DEVELOPMENT REVIEW BOARD

Parks and Recreation Department

PR-2020-004448

PS-2022-00155 – SKETCH PLAT IDO - 2021

LANDSCAPE
SITE PLAN
CALCS
LP-101

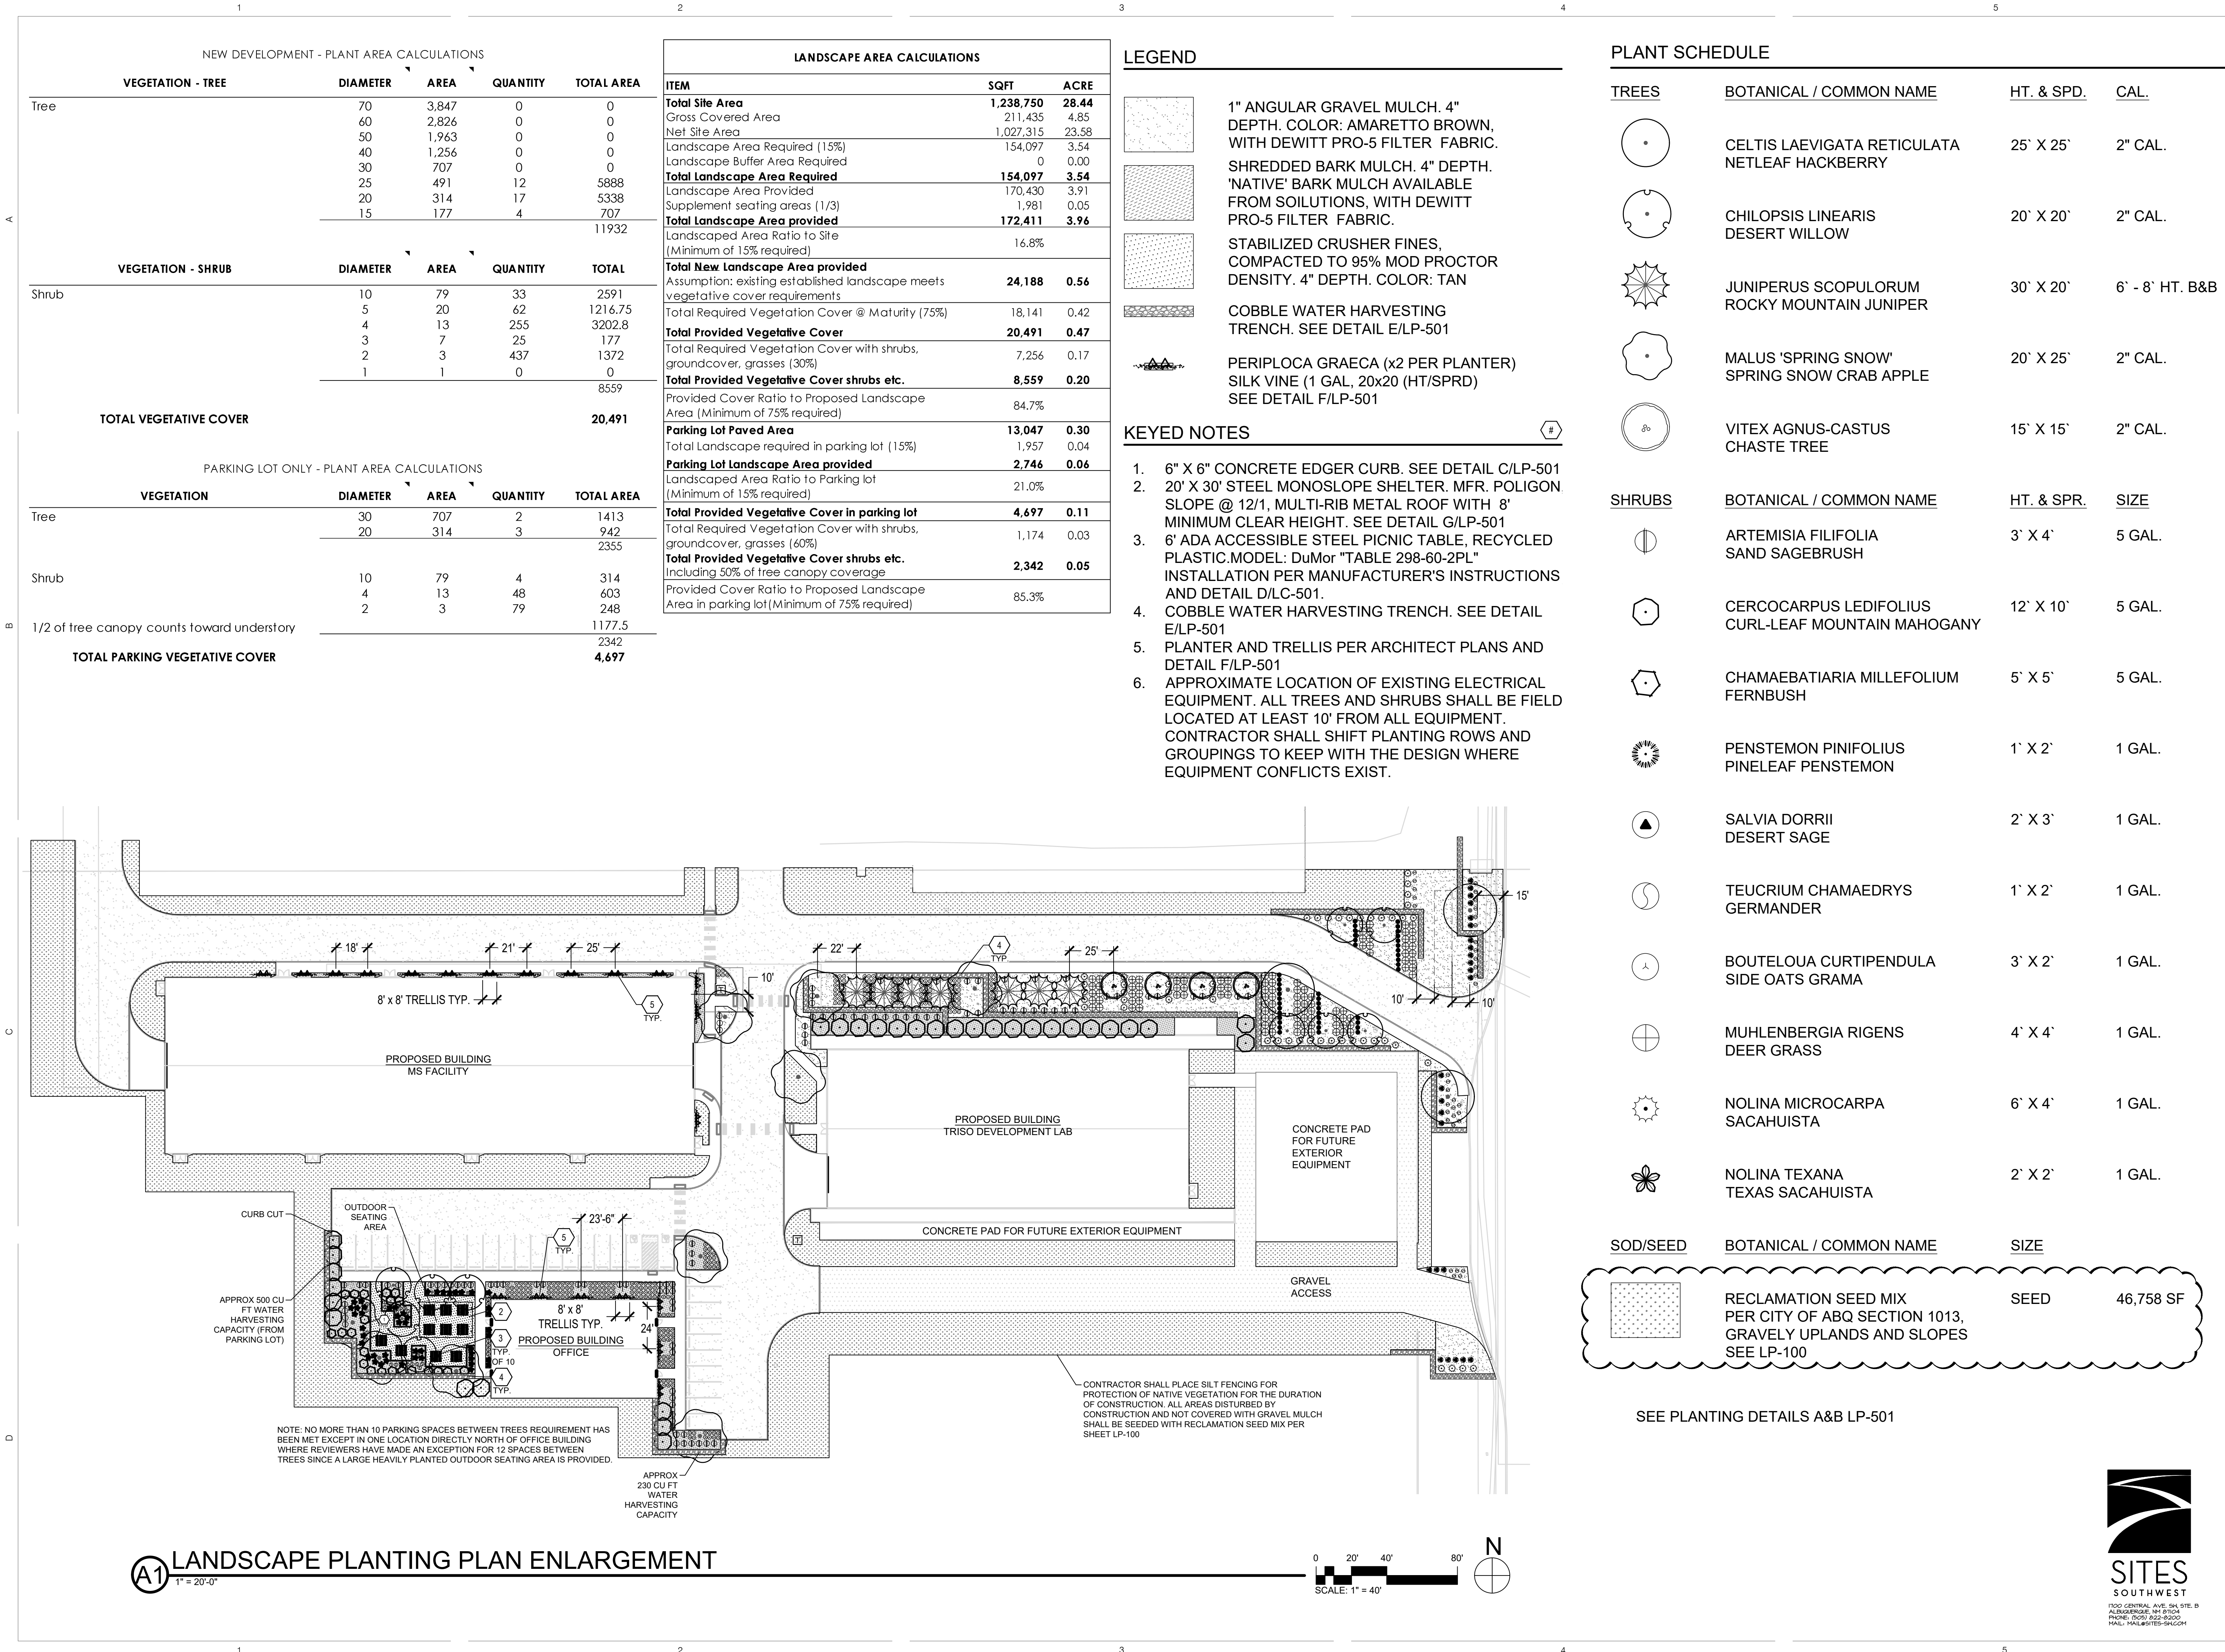
Please note organic mulch per IDO 5-6(C)(5) in planting details on page LP-103.
